9 CMU TRASH ENCLOSURE DTL
SCALE: 3/8"=1'-0"

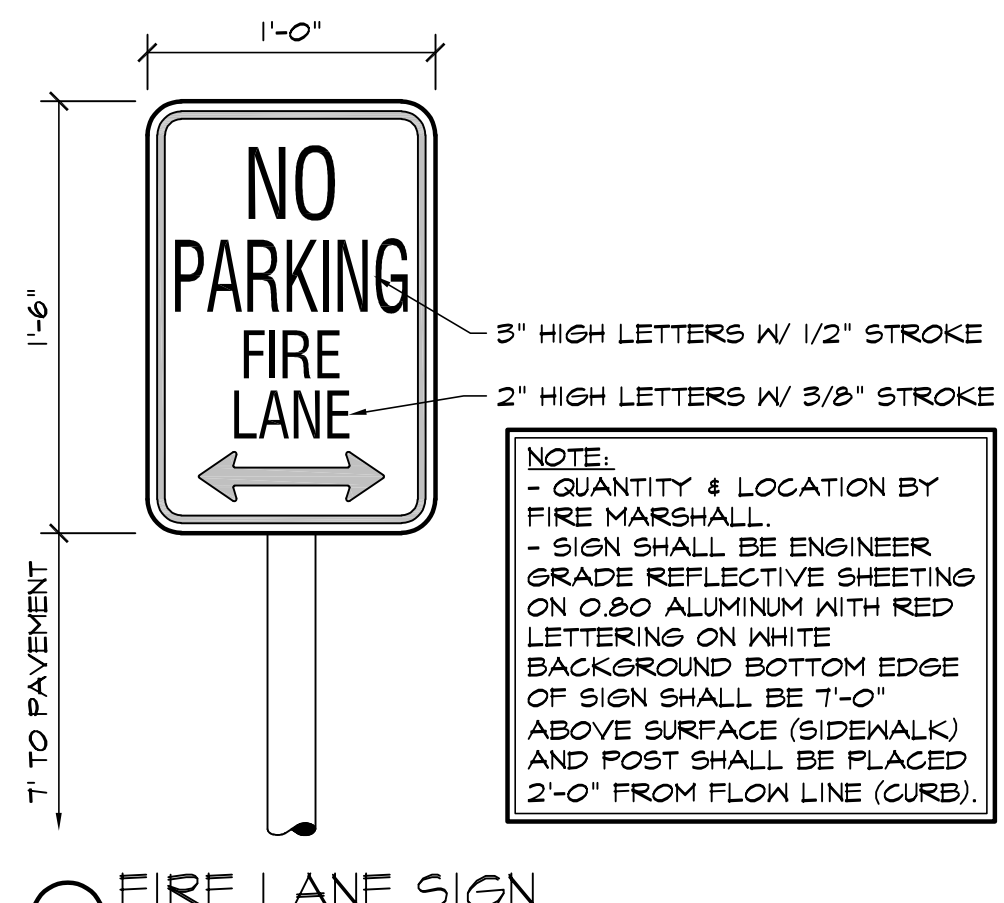
Advisory comment: If dumpster enclosure height exceeds 7' tall it will require a building permit and would not be permitted within the building setback area. So far it is not shown to be that tall so this is just an advisory comment.
